Application: SSI 7485

I write regarding the proposed modification to M4-M5 Link, Mod 2 The Crescent overpass and changes to pedestrian infrastructure in North Annandale, Rozelle and Rozelle Bay Foreshore area.

Figure 4-2 Pedestrian and cyclist bridge infrastructure options

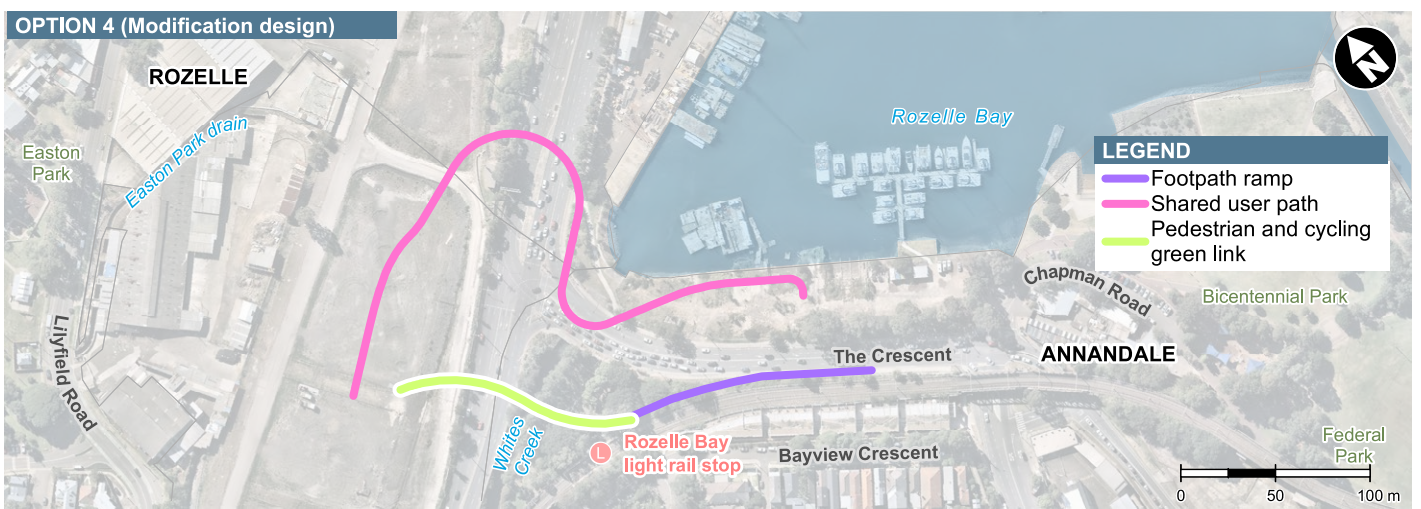
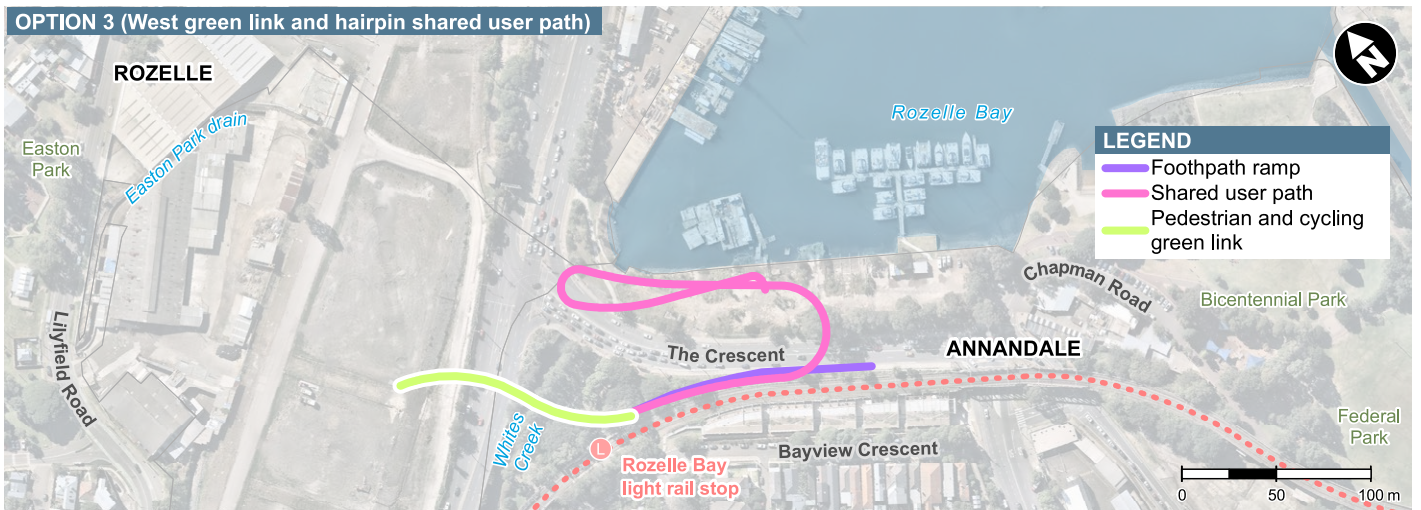
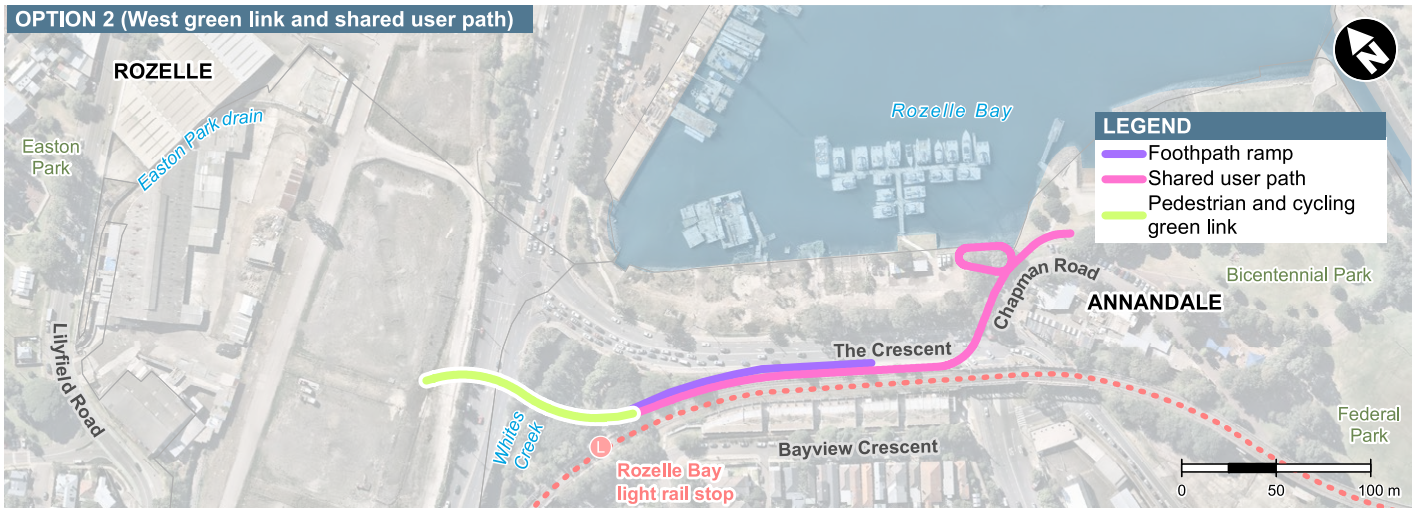
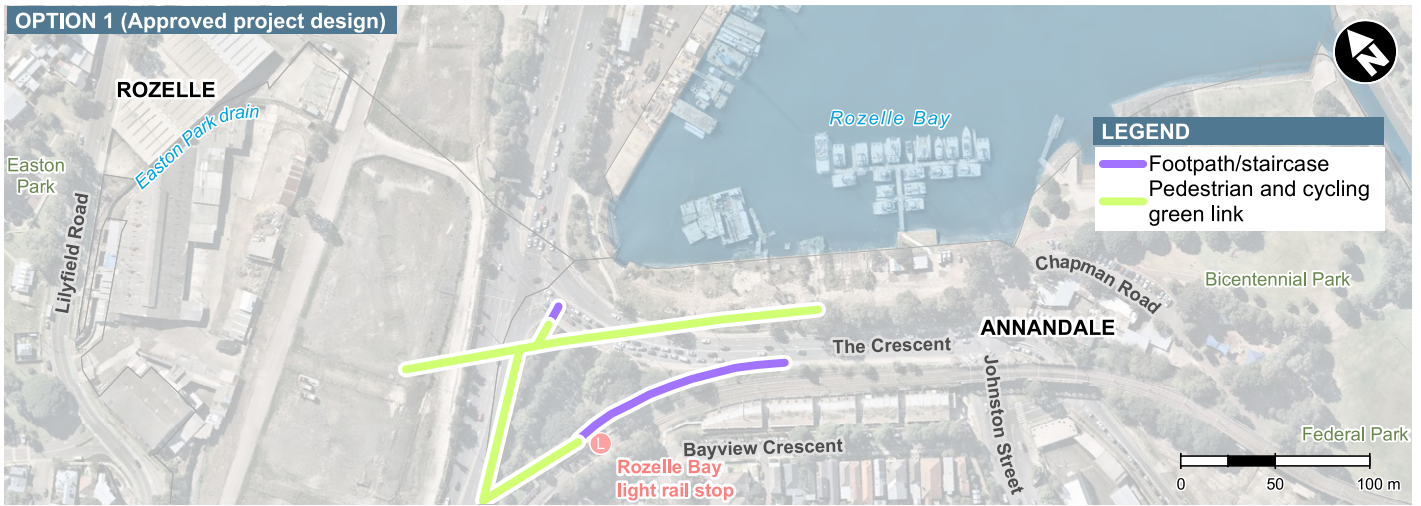
I request RMS work with the community to explore alternate design options to the proposed new car overpass design and the changed pedestrian and cyclist links. I am seeking the reinstatement of the safe, direct access from the approved EIS GreenLink to create a continuous green open space connection from the Rozelle Rail yards and Annandale to the foreshore. The GreenLink was more than just a walk way - it put people central to the design, maximising safety, and providing much needed accessible open space for the community now and into the future Bays Precinct design.

- The significantly reduced safety and increased risk for pedestrians and cyclists with removed access over The Crescent to Bicentennial Park and the increased traffic along Johnson Street.
- Being required to cross five sets of pedestrian lights at The Crescent as my option to reach the foreshore from Annandale or from Rozelle Bay light rail stop.
- Removal of direct active links to the foreshore, cutting the community off from the area and the proposed revitalisation of the entire Bays Precinct, including linking the Light Rail and Bus stops to a Ferry wharf and Metro station.
- Urban and landscape design that is being built before a finalised Masterplan for the area.
- Traffic changes that limit movements around the suburb and create further congestion in the local streets of Annandale, Forest Lodge, Glebe, Lilyfield and Rozelle with no planning to deal with these.

- Reinstate the GreenLink connecting communities and green open space from Rozelle to Bicentennial Park.
- Relocate and design pedestrian and cyclist connections that are continuous, safe and direct.
- Design the modification infrastructure and active links in response to the character of the suburbs, the location of the foreshore and it's potential future development.
- Provide pedestrian and cyclist paths that maximise people safety and do not force us onto busier streets, unsafe concrete plazas and caged walkways.
- Integrate active and direct connections to all active transport – including the future Metro West and Foreshore Ferry Wharf.
